COLORADO
Department of Transportation

December 18, 2020

SH21A
El Paso County

RE: Trails at Aspen Ridge_Legacy Hills Rd. / Bradley Rd. - SIGNAL **SubNo.2** - review of construction drawings.

BRADLEY ROAD / LEGACY HILL DRIVE ROAD & SIGNAL PLANS		
SIGNAL POLE & CONDUIT PLAN		
Subset: SG	Subset Sheets: 3 of 4	Sheet No: 3

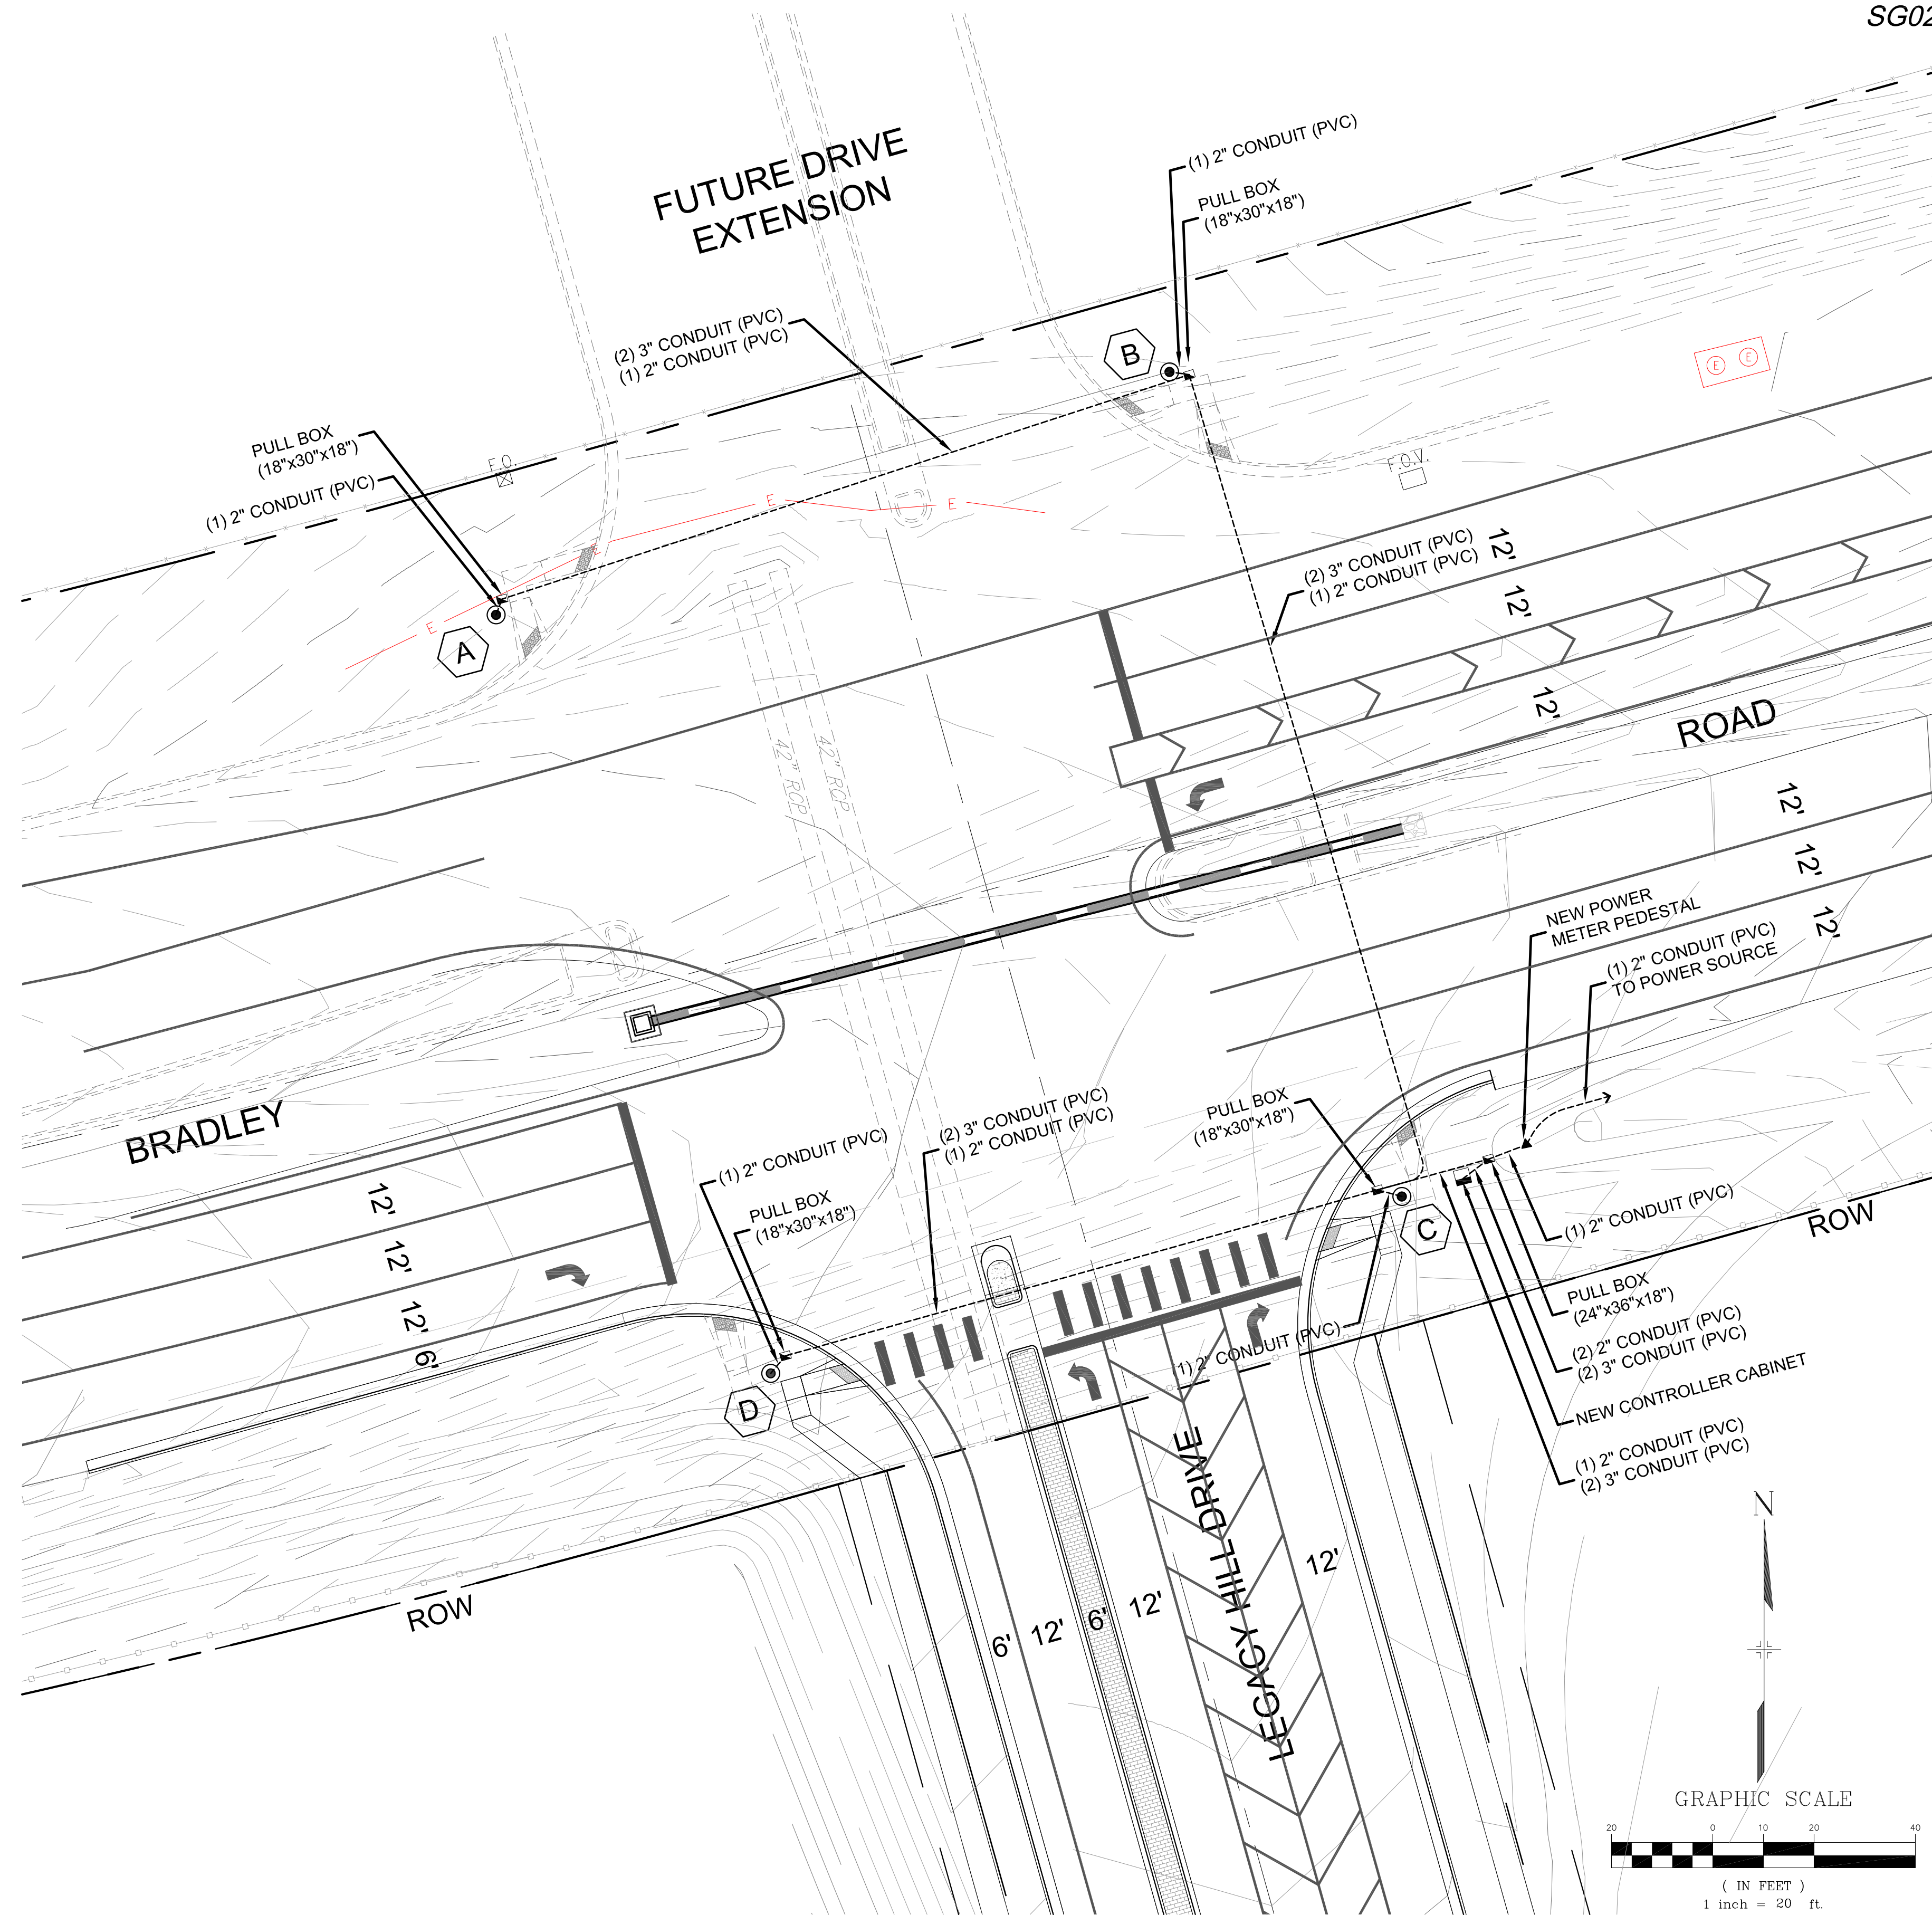
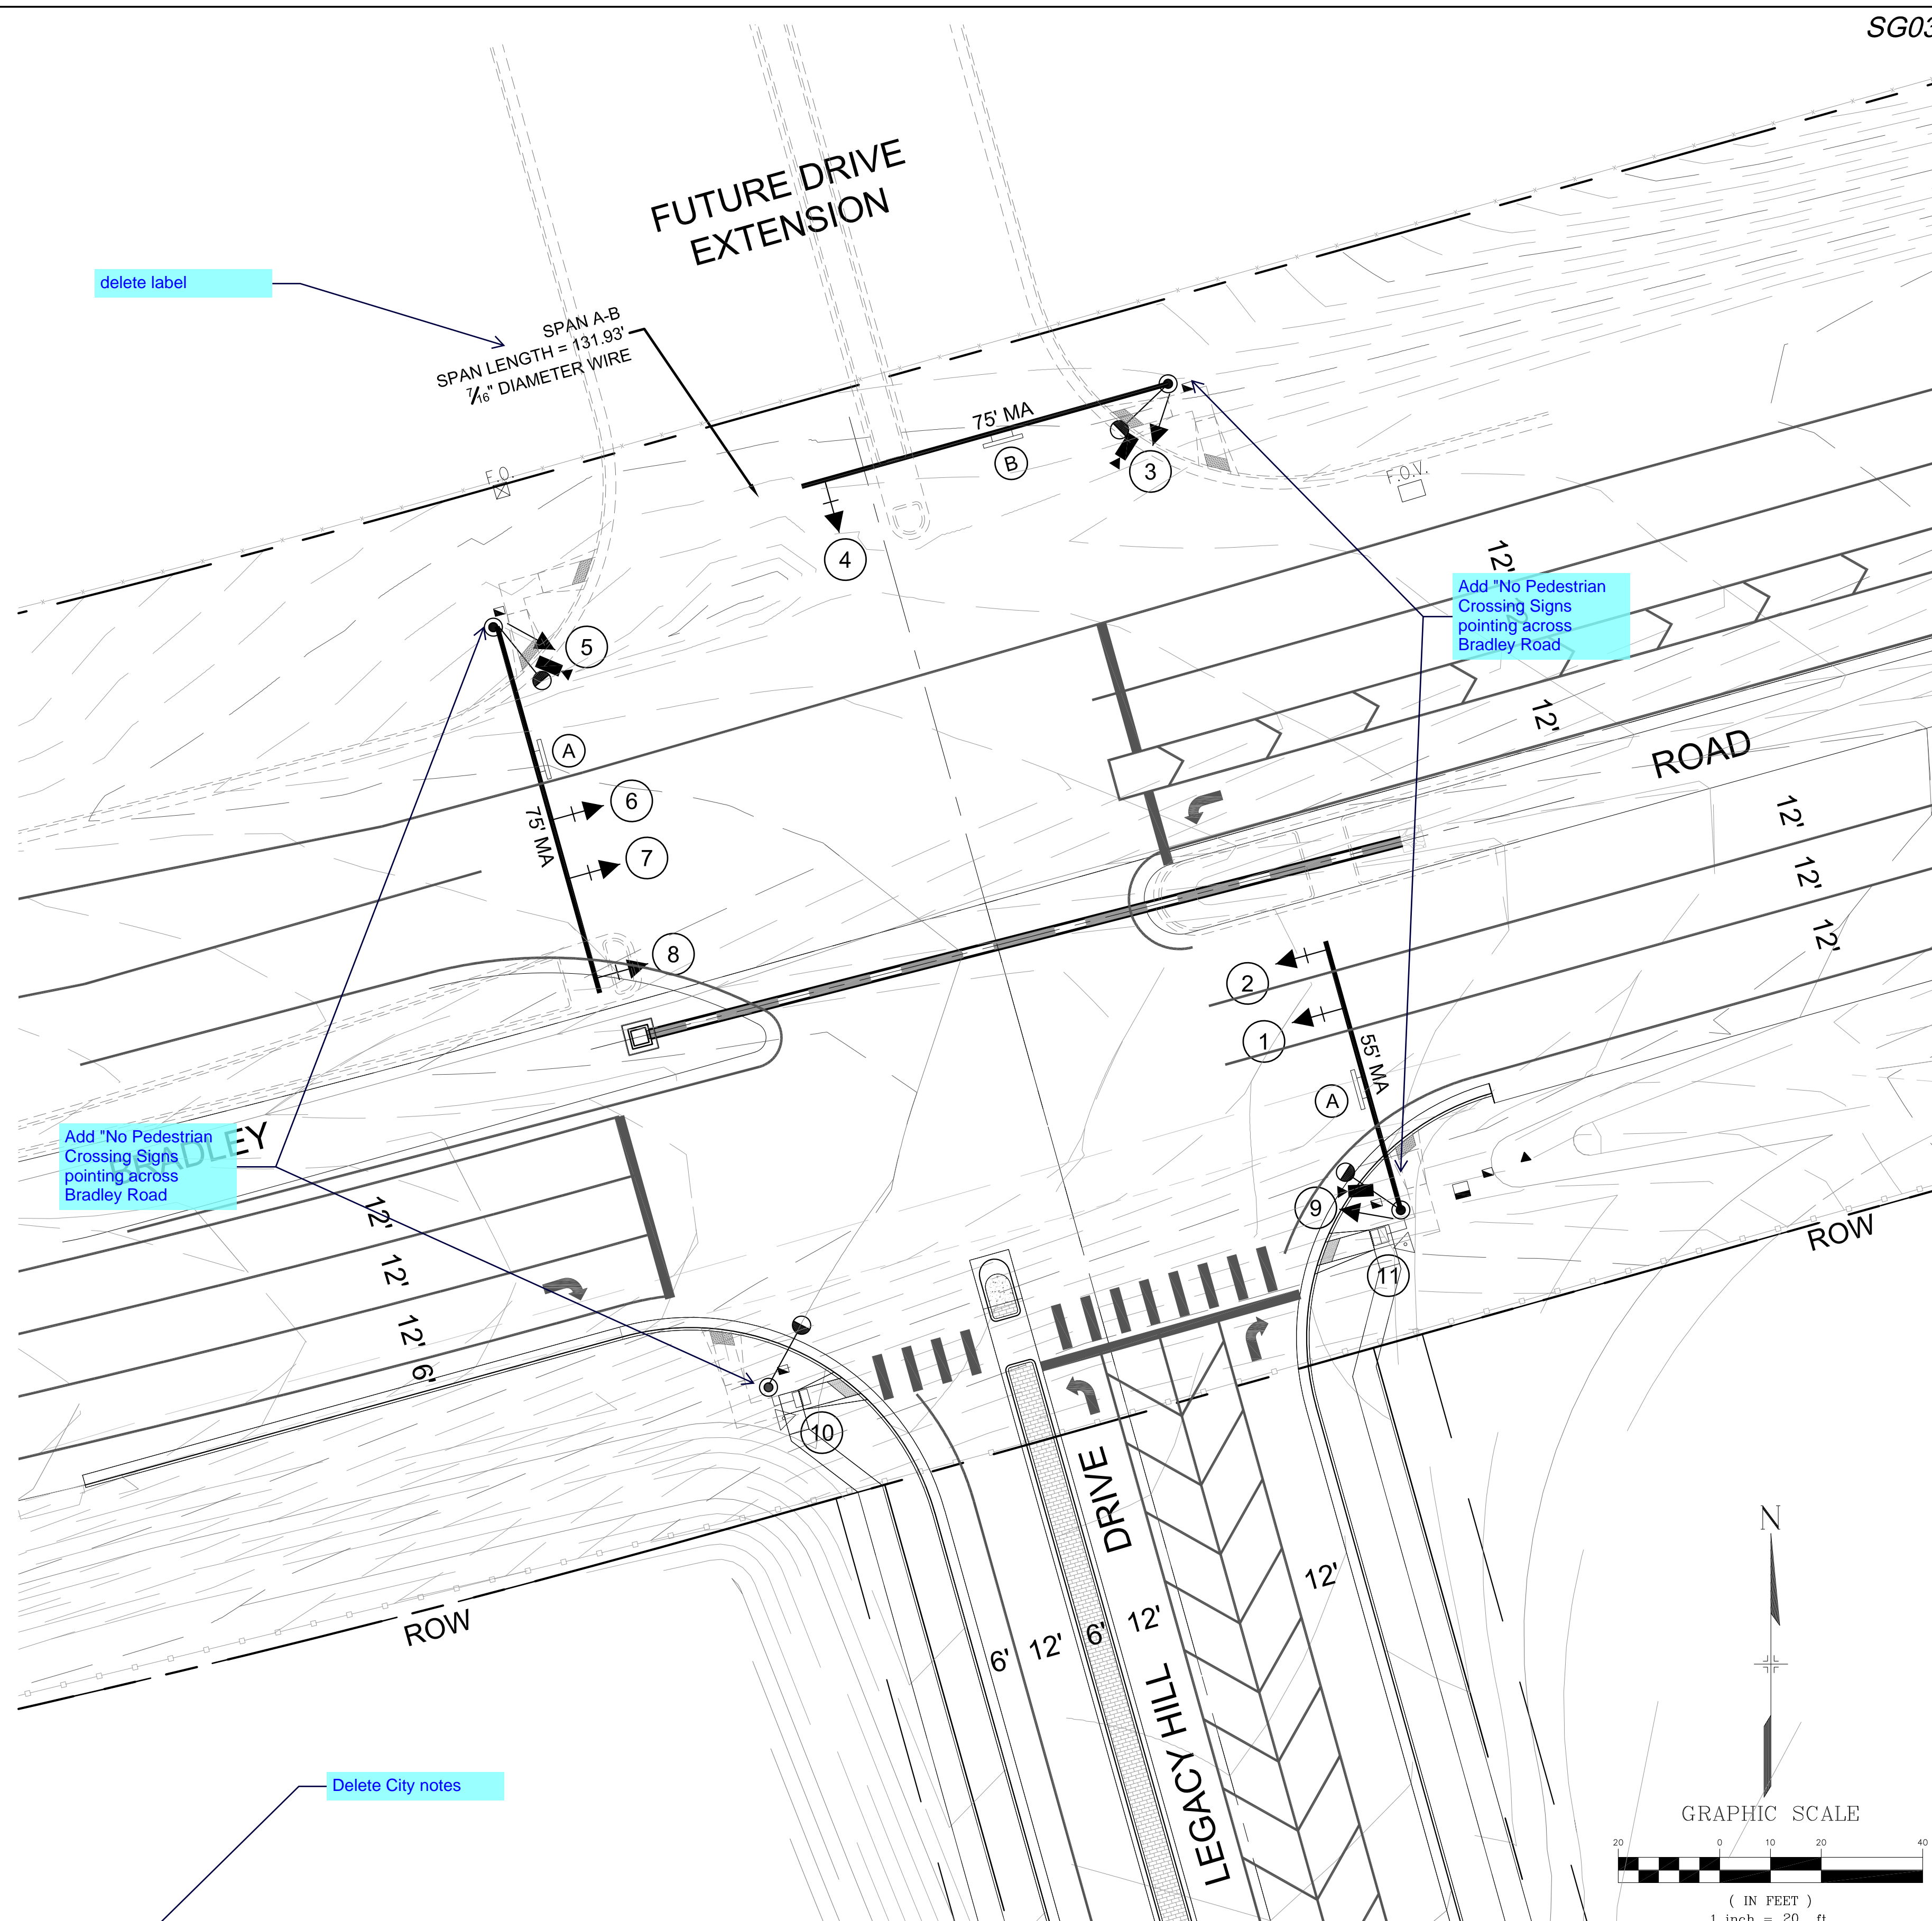
- **Traffic Operations comments dated 11/20/2020:**
 - a. **Per the comments submitted on Nov. 20, 2020, the following need to be included as part of the construction plans:**

- b. **Plans need to include the construction of the SB dual left turn lane on Powers (Sh21).**
 - c. **Plans need to include the lengthening of the NB right turn decel lane.**

- **Traffic Operations comments dated 10/01/2020**
 - a. Over the past several years, CDOT has made multiple comments regarding the spacing between SH21 and this proposed signal - comments have essentially been dismissed. While I understand that this location of the proposed signal is barely beyond the minimum 550' from SH21, in the future Bradley and Powers will eventually become an interchange. It is highly likely that the proposed location will be within the functional area of the the interchange requiring modifications and possibly the removal of full movement access to Legacy Hills Rd north and south to this development. I do not see the need to push the spacing so tight as this is virgin ground. CDOT requests, again, that the signal be shifted east along Bradely (approximately 750') to avoid future access modifications.
